re: **Response to City Comments**
 Proposed School Development
 620 Triangle Street – Ottawa, Ontario

date: September 17, 2025

file: PG7249-MEMO.02

Further to your request and authorization, Paterson Group (Paterson) has prepared the current memorandum to provide geotechnical responses to City of Ottawa comments regarding the current geotechnical investigation report (Geotechnical Report PG7249-1 dated September 9, 2024) prepared for the aforementioned site.

SERVICING PLAN

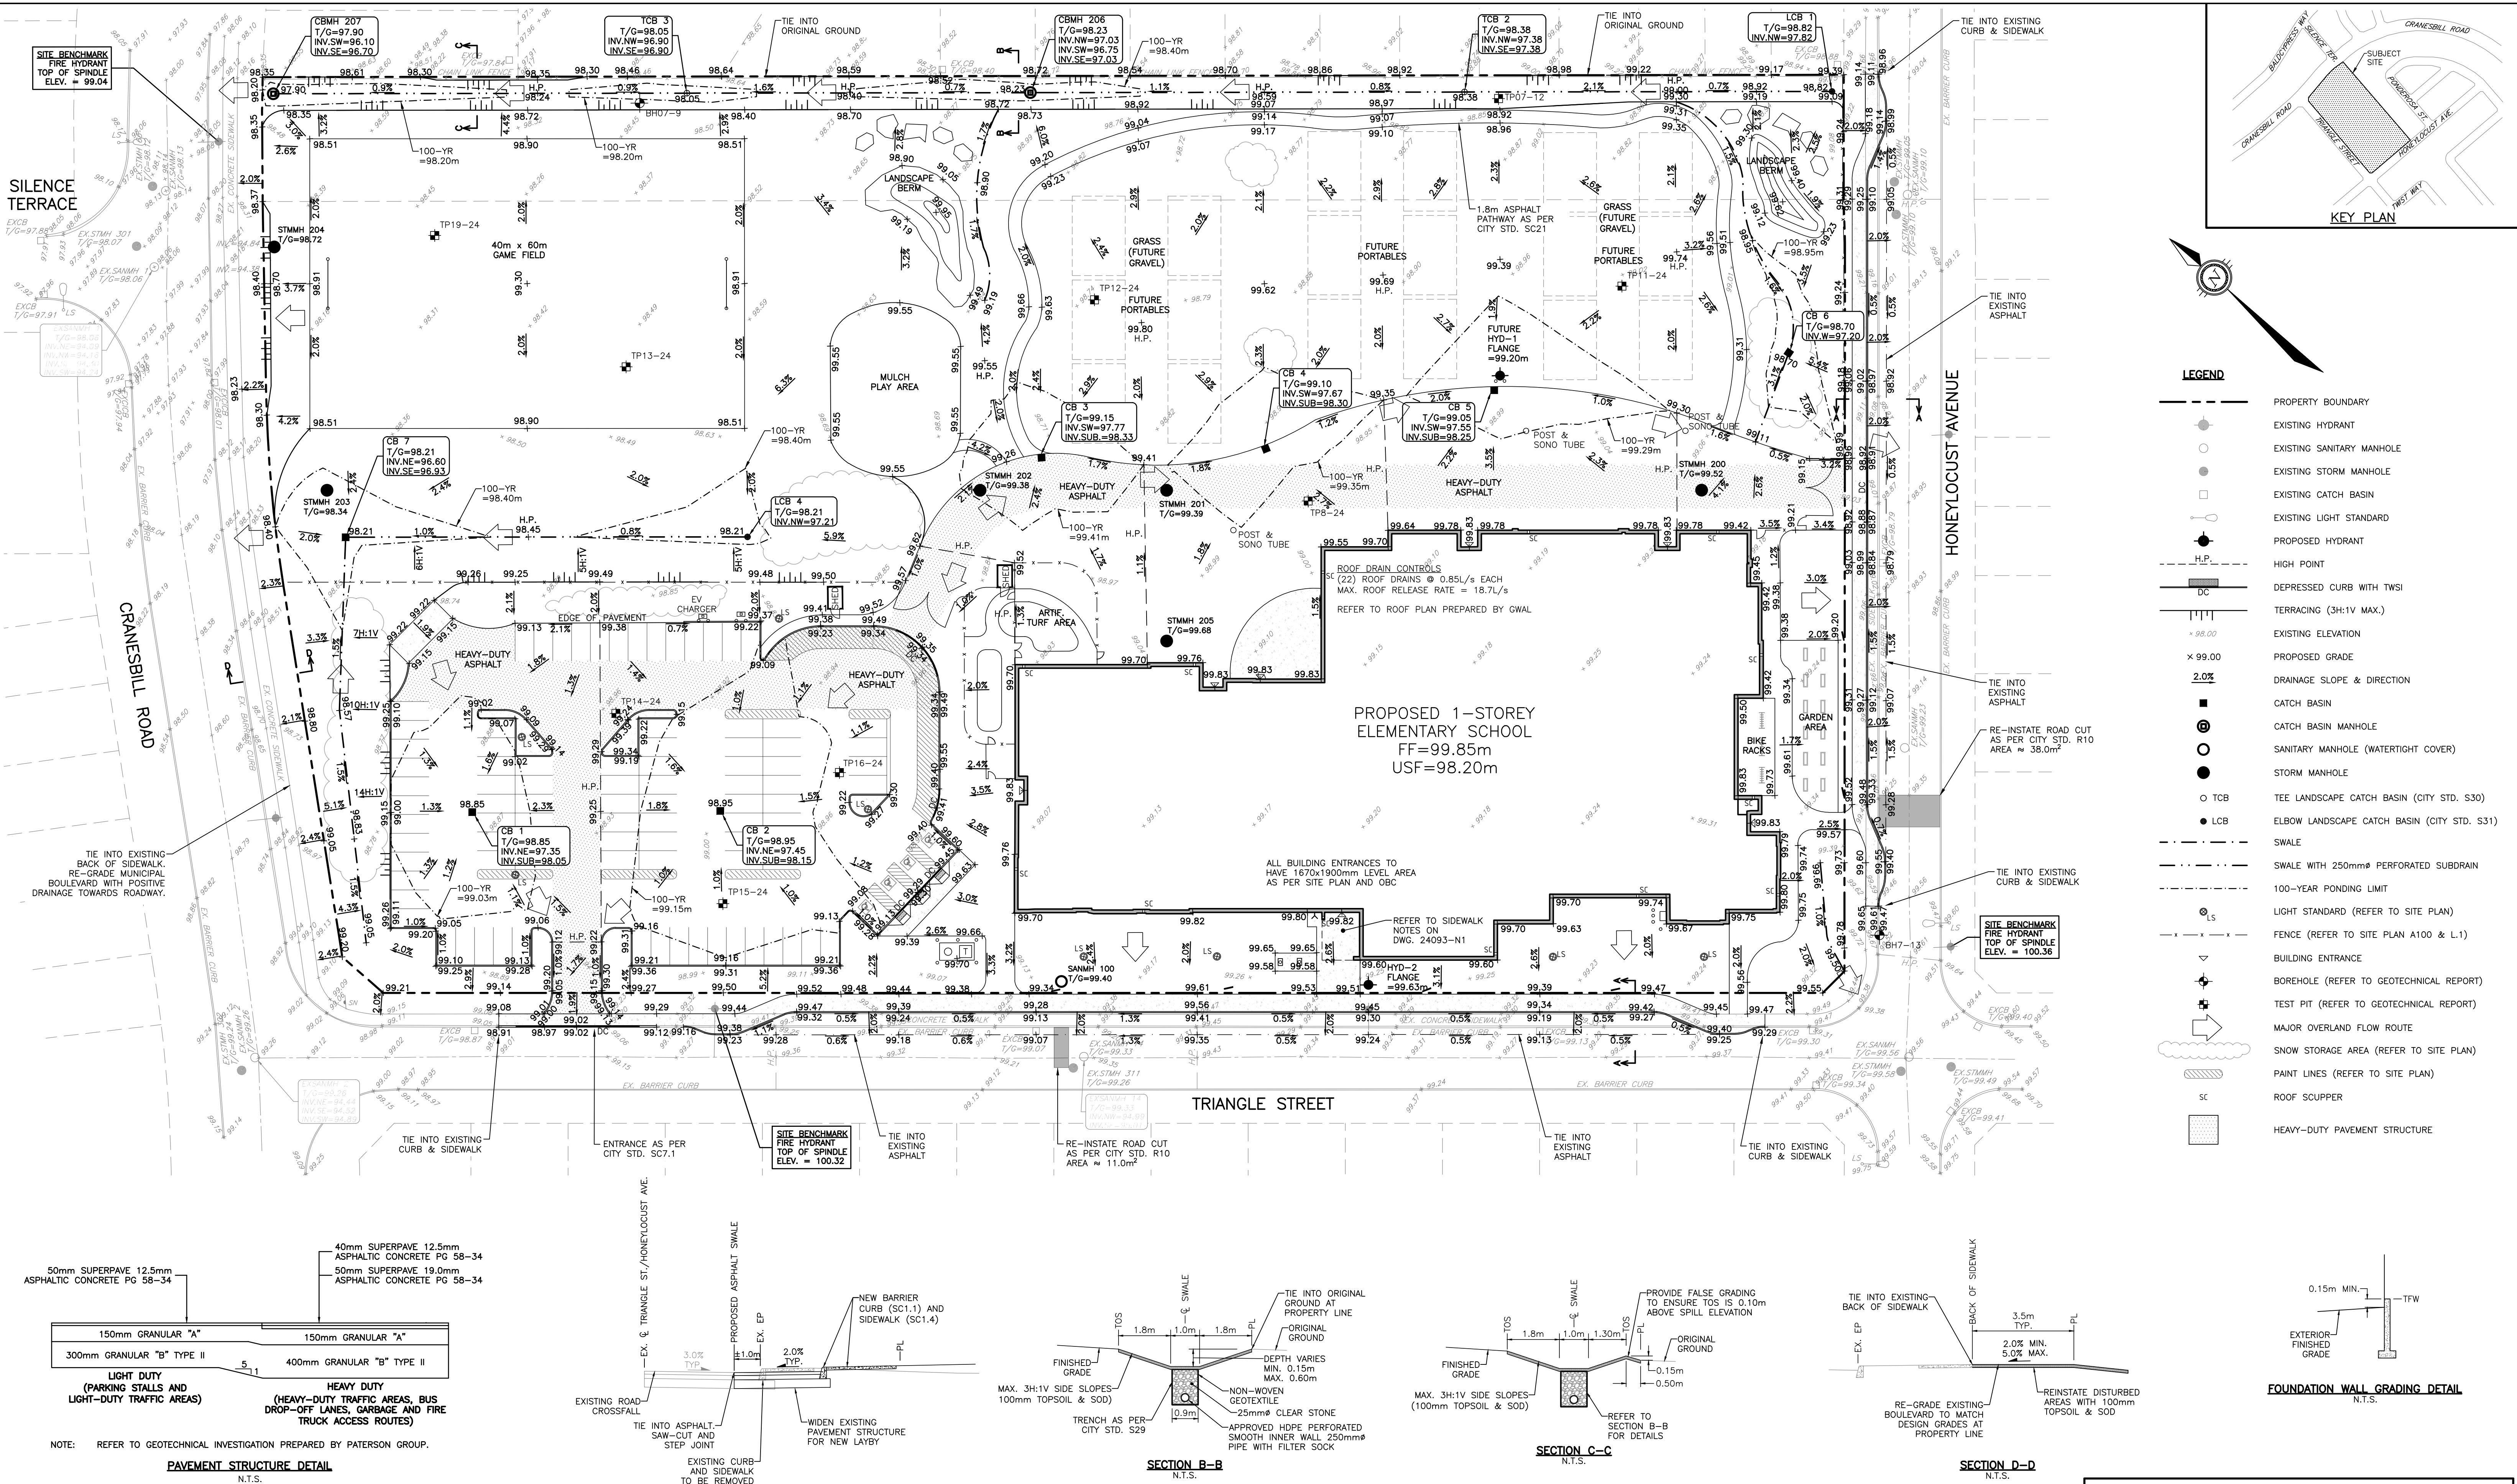
Comment C6: *Provide a memo or section in the report confirming review of the civil grading and servicing plans and its conformity to the geotechnical recommendations.*

Response: Reference should be made to our memorandum PG7249-MEMO.03 which provides the grading plan review. In summary, the proposed grading is acceptable from a geotechnical perspective.
